The SoS asks for evidence; the Draft Arup Report provides mostly opinions or demonstrably wrong conclusions.

The SoS asks for evidence; the Draft Arup Report provides 47 Opinions, 41 wrong conclusions out of 53, using out of date information 18 times, omits many key factors, and mostly cites reports prepared for opponents of Manston Airport.

Dr. Beau Webber

Chairman, Save Manston Airport association.

Changes in Bellycargo and Freighter air freight tonnages mid-2019 to Sept 2021. - 2021-11-17

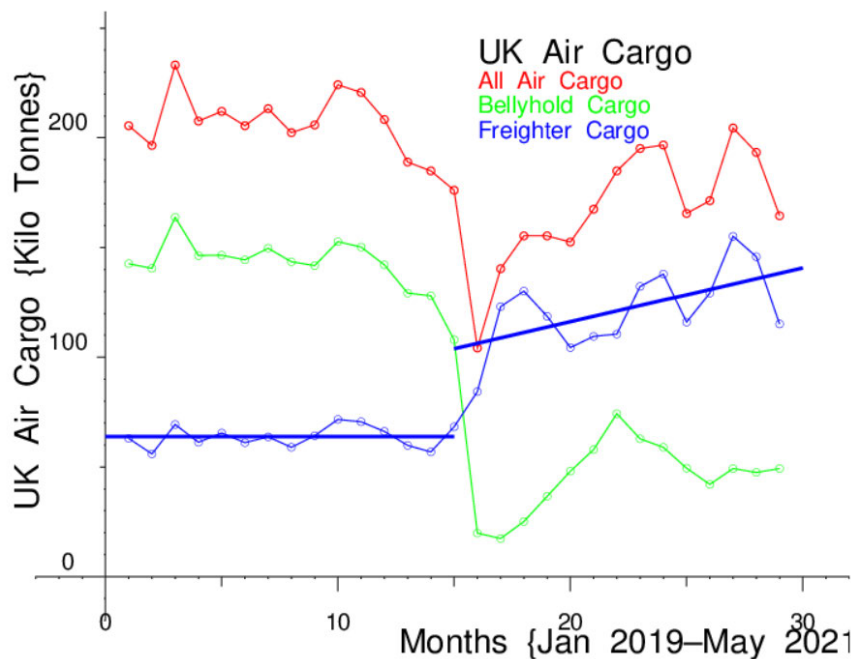
We note that the Draft Arup Report reaches conclusions on pages : 16, 17, 18, 22, 23, 24, 25, 28, 29, 30, (sometimes more than once per page), that are at variance with the data and graphs in :
Dr. Webber's submission :

"Changes in Bellycargo and Freighter air freight tonnages mid-2019 to Sept 2021."

This is also cited in *"SMAa response to Arup report" (Part-1 page 4)*, and referred to as Graph 1 :

Figure 4.5: Air Freight Tonnes Handled at All UK Airports by Aircraft Type and Long Haul Bellyhold Capacity

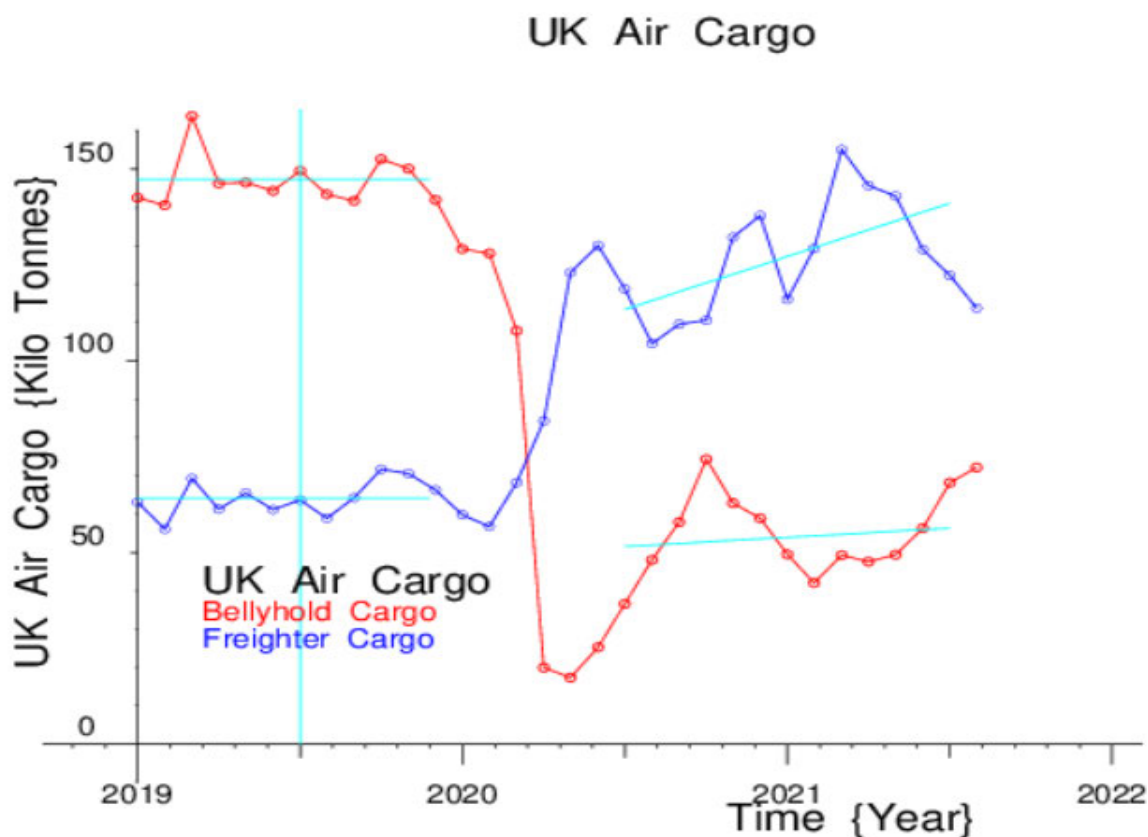
P28	Figure 4.5 of their report, replicated as Figure 2. this evidence does demonstrate that long-haul bellyhold capacity is likely to recover to pre-pandemic levels	York Aviation on behalf of Jennifer Dawes		0	1	1			0	1		Figure 4.5 uses incorrect data and the wrong metric so cannot be relied upon. SMAa Figure X shows that Mid-2019 to late 2021 Bellyhold suffered a major reduction in tonnage to about 1/3, with little sign of recovery yet.	SMAa Graph 1 (Part 1 page 4) [CAA] SMAa representation to the Secretary of State - Response to Arup Report - part 1
P29	There is some available capacity for long-haul bellyhold freight, which is expected to increase as passenger demand recovers.	York Aviation on behalf of Jennifer Dawes	1	0	1	1			0	1		There is no evidence supporting this opinion. SMAa Figure X shows that Mid-2019 to late 2021 Bellyhold suffered a major reduction in tonnage to about 1/3, with little sign of recovery yet. Arup fail to understand the key role of dedicated freighters. "There are several key reasons for freighter preference in air cargo flows: 1) Most passenger belly capacity does not serve key cargo trade routes; 2) twin-aisle passenger schedules often do not meet shipper timing needs; 3) freight forwarders prefer palletized capacity, which is not available on single-aisle aircraft; 4) passenger bellies cannot serve hazardous materials and project cargo, a key sector in air cargo flows; and 5) payload-range considerations on passenger airplanes may limit cargo carriage, which decreases the likelihood that cargo will arrive at its destination on time."	SMAa Graph 1 (Part 1 page 4) [CAA] Boeing WACF
